Oxford City Council

Application under S.73 to vary the approved drawings for the site.

Prior approval for demolition of existing three storey office building (Use Class E) and erection of four storey building to provide 20no. flats (Use Class C3) and provision of bin stores. This application is assessed solely in respect of transport and highway impacts; contamination risks; flooding risks; design; external appearance; provision of adequate natural light; amenity; impacts of noise from commercial premises; impact on business and new residents of increase in residential use in the area; impact on heritage and archaeology; the method of demolition; landscaping; and air traffic and defence asset impacts (amended plans). 244 Barns Road Oxford Oxfordshire OX4 3RW

Application Ref. 23/00623/VAR (a variation to prior approval 21/01539/DDW56)

E1
West

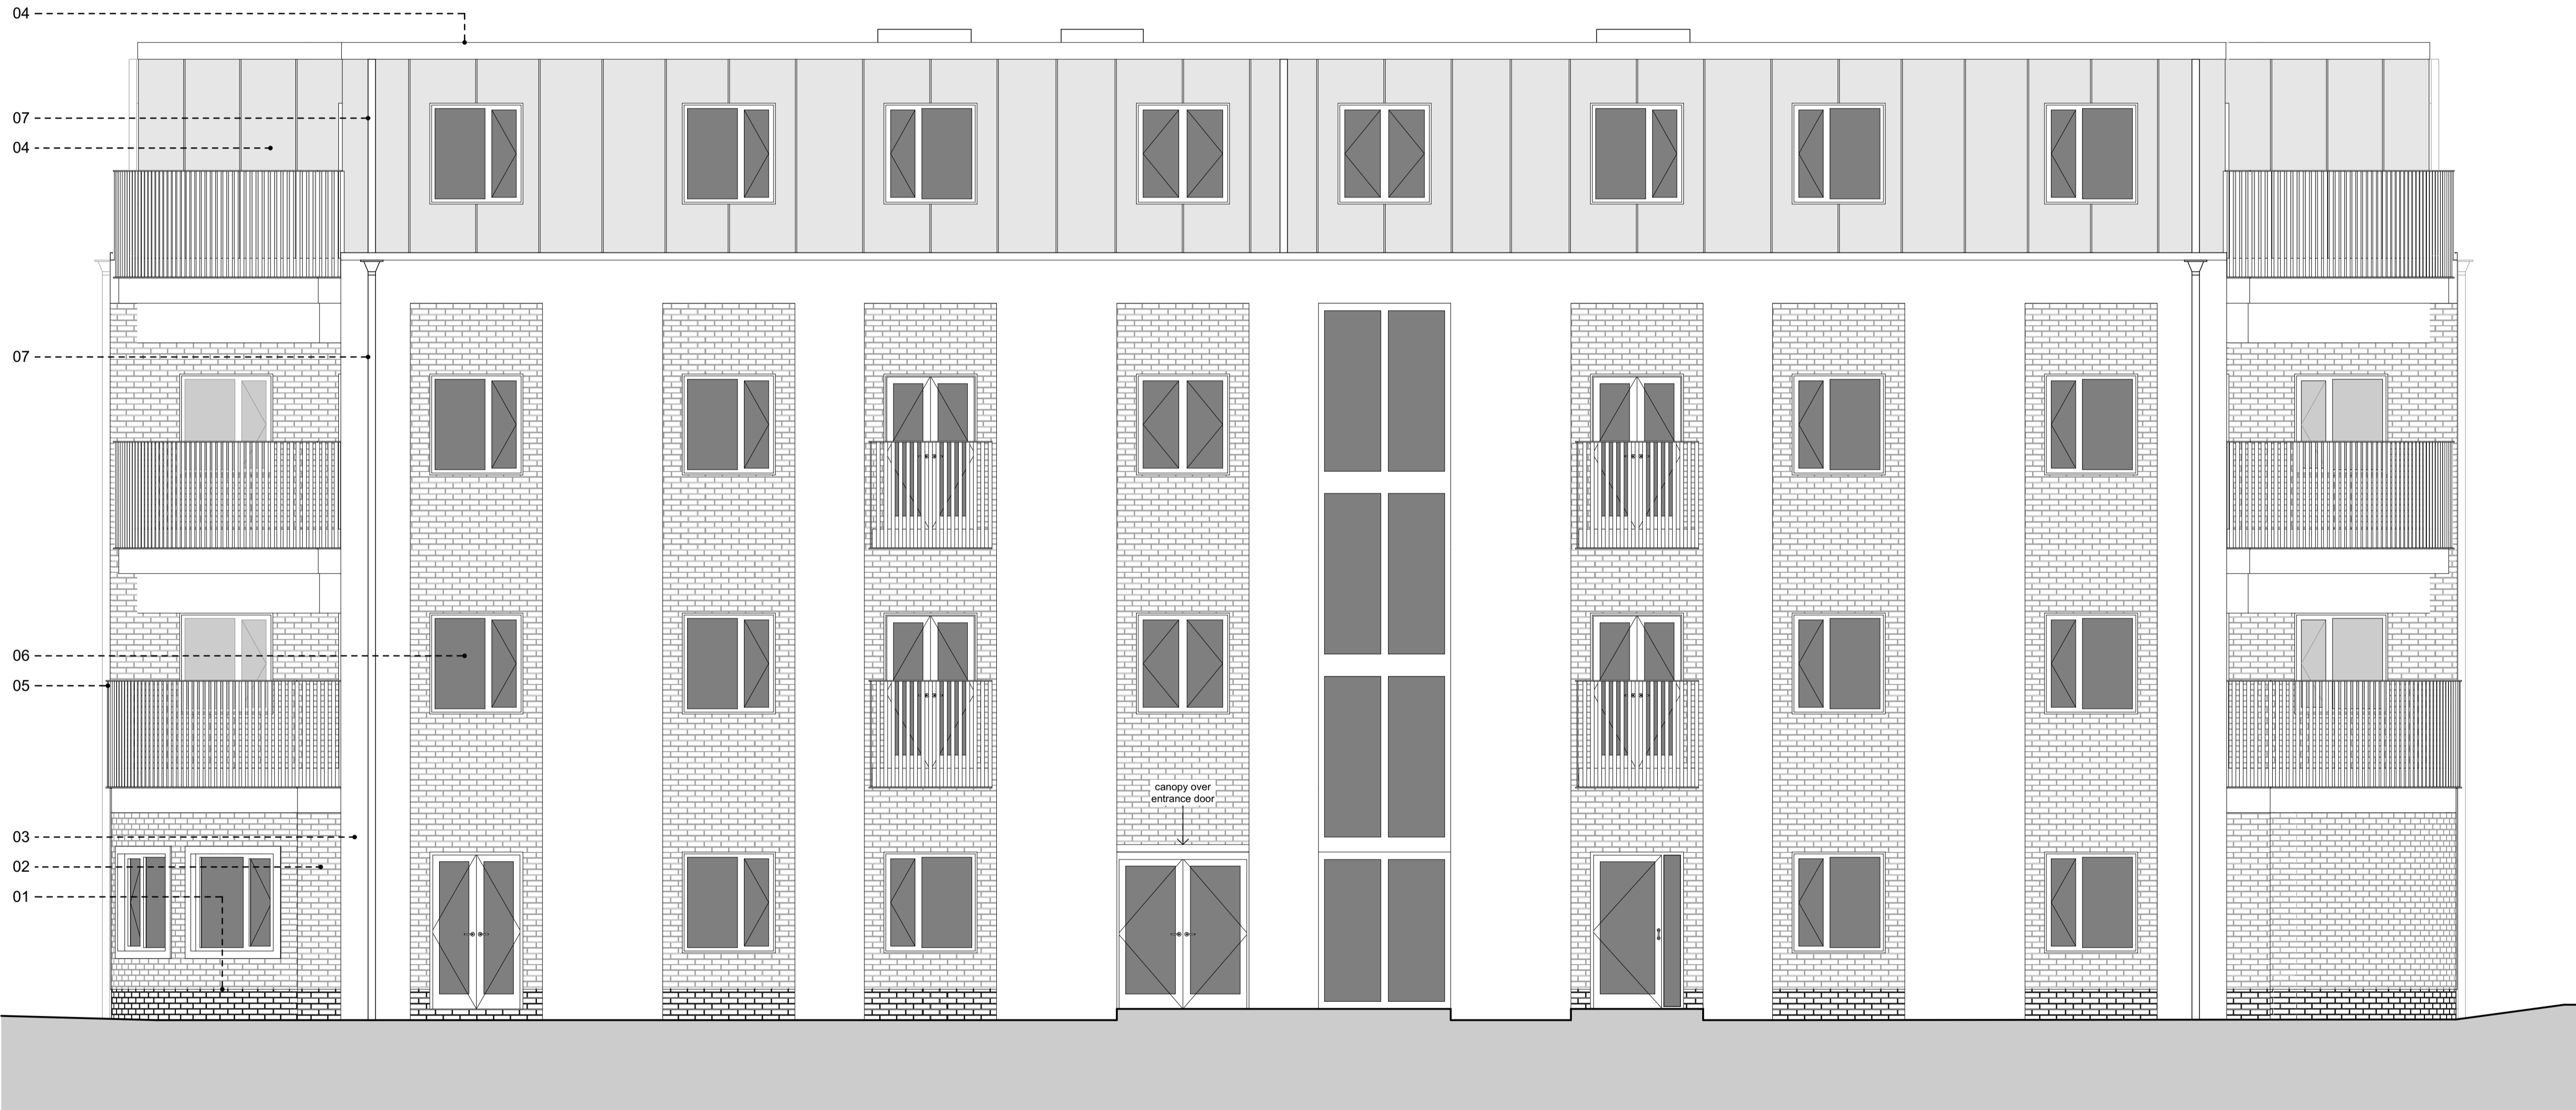
Ground floor additional window opening added;
Main access door added and related windows for stair core
First and second floor central balconies removed and replaced with Juliette balconies;
Third floor central balconies removed;
Third floor corner balcony doors no moved to South and North elevations.

LG
Level Ground

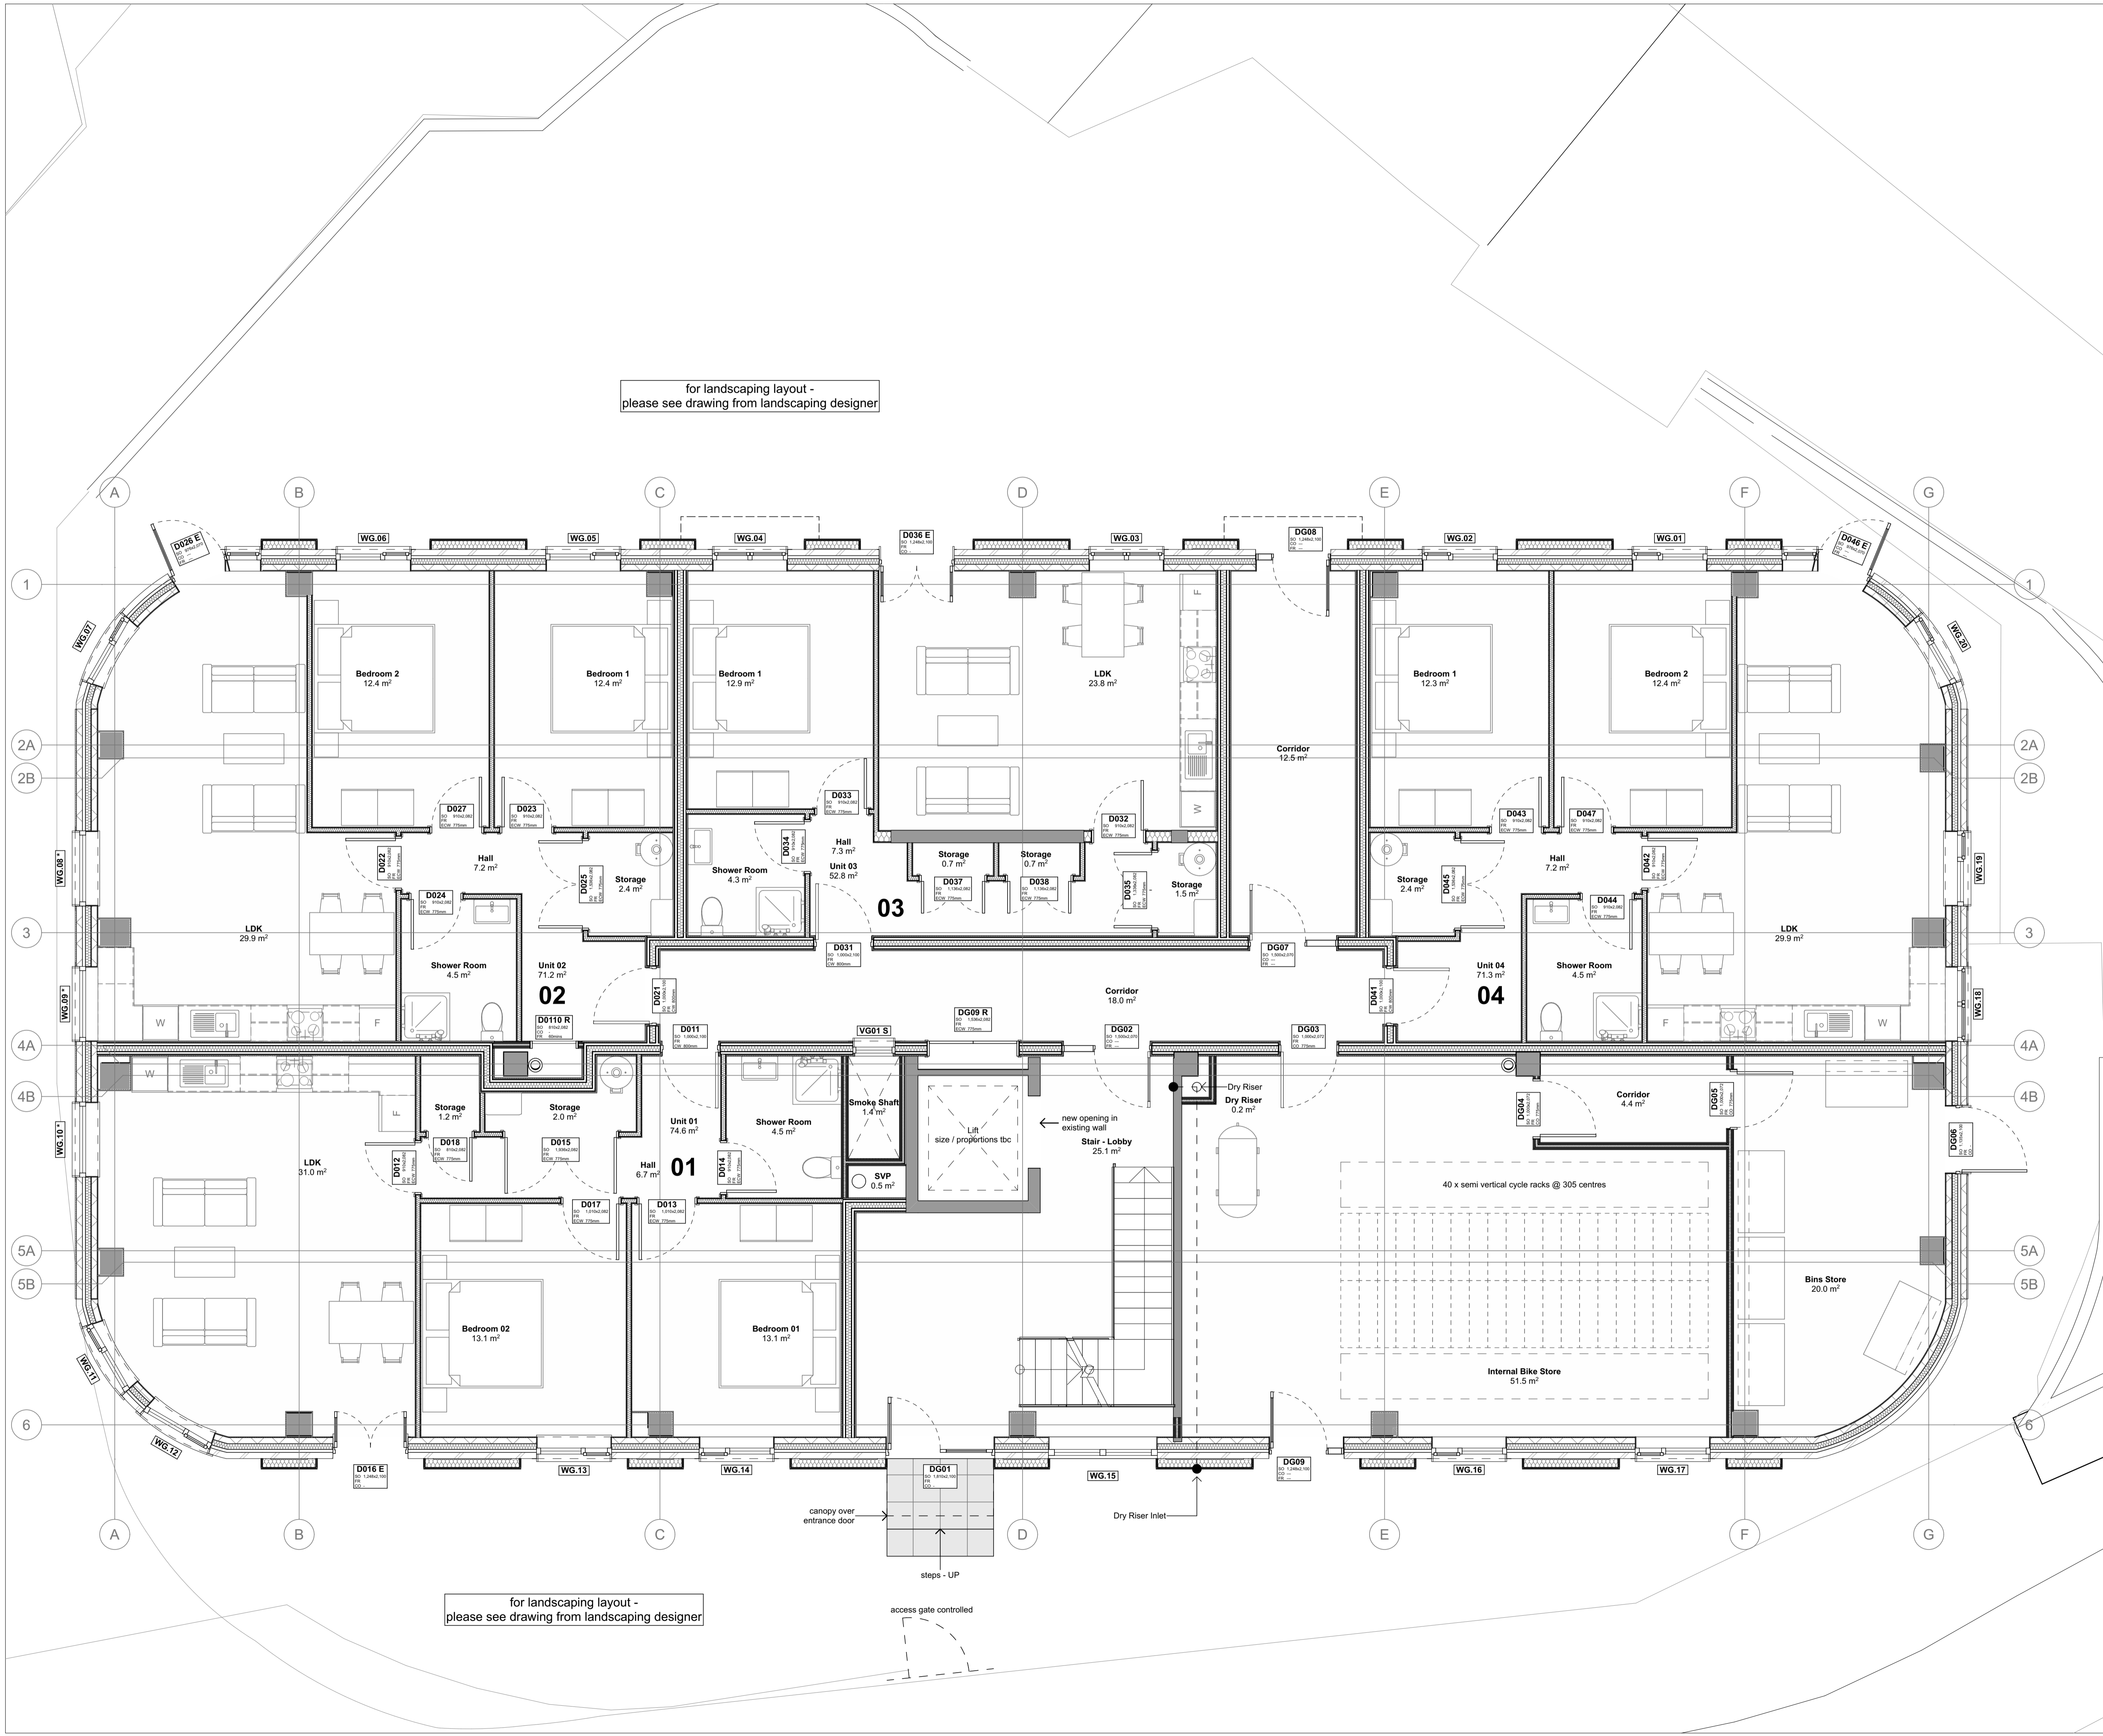
- Stair-core moved from rear to front;
- Terrace removed corner rear units with backdoor onto private garden; and
- Access to the bike store moved.

DRAWING TITLE:  
**PROPOSED LANDSCAPE PLAN**

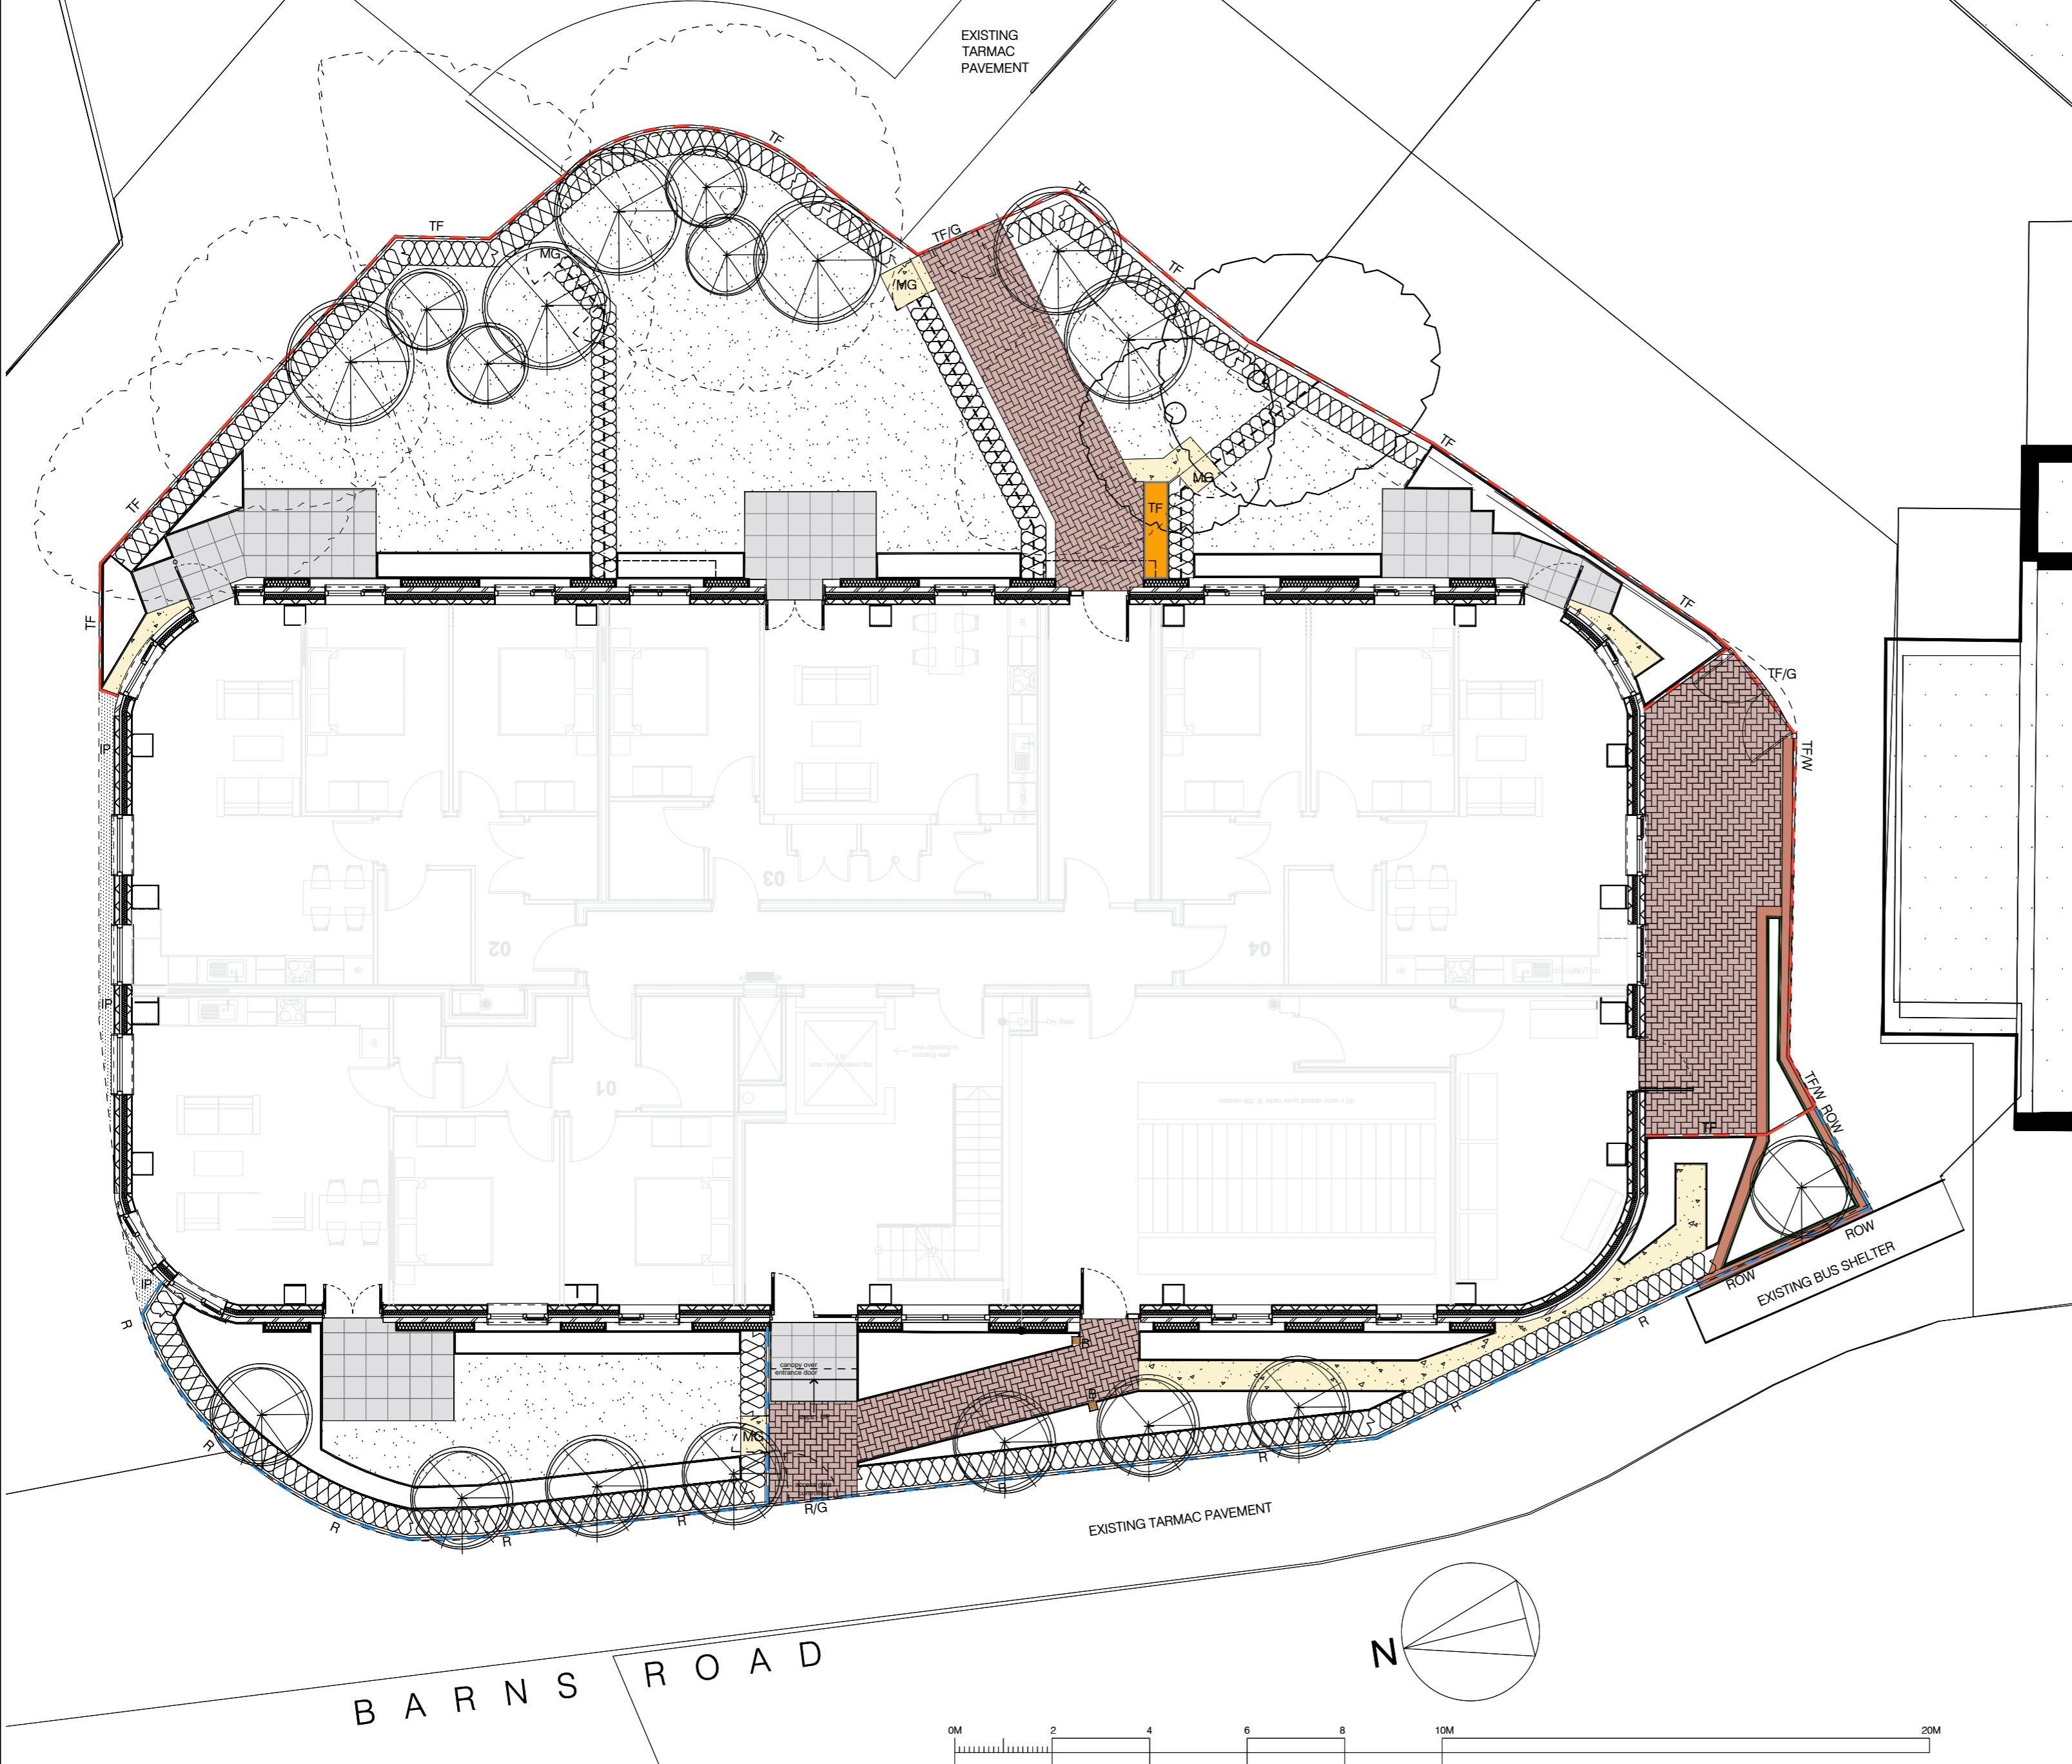
The addition of a back garden for unit 2 (with its related access) necessitates the removal of the existing planter with existing trees. Such would be mitigated by replacement planting of appropriate native species of a type and maturity recommended by our arboriculturist to reduce the impact of removal and ensure that privacy is maintained while improving the light to the units themselves.

The rotation of the building through 180 degrees means that there will be more private gardens to the rear; and
The removal of the planter at the rear and replacement planting.
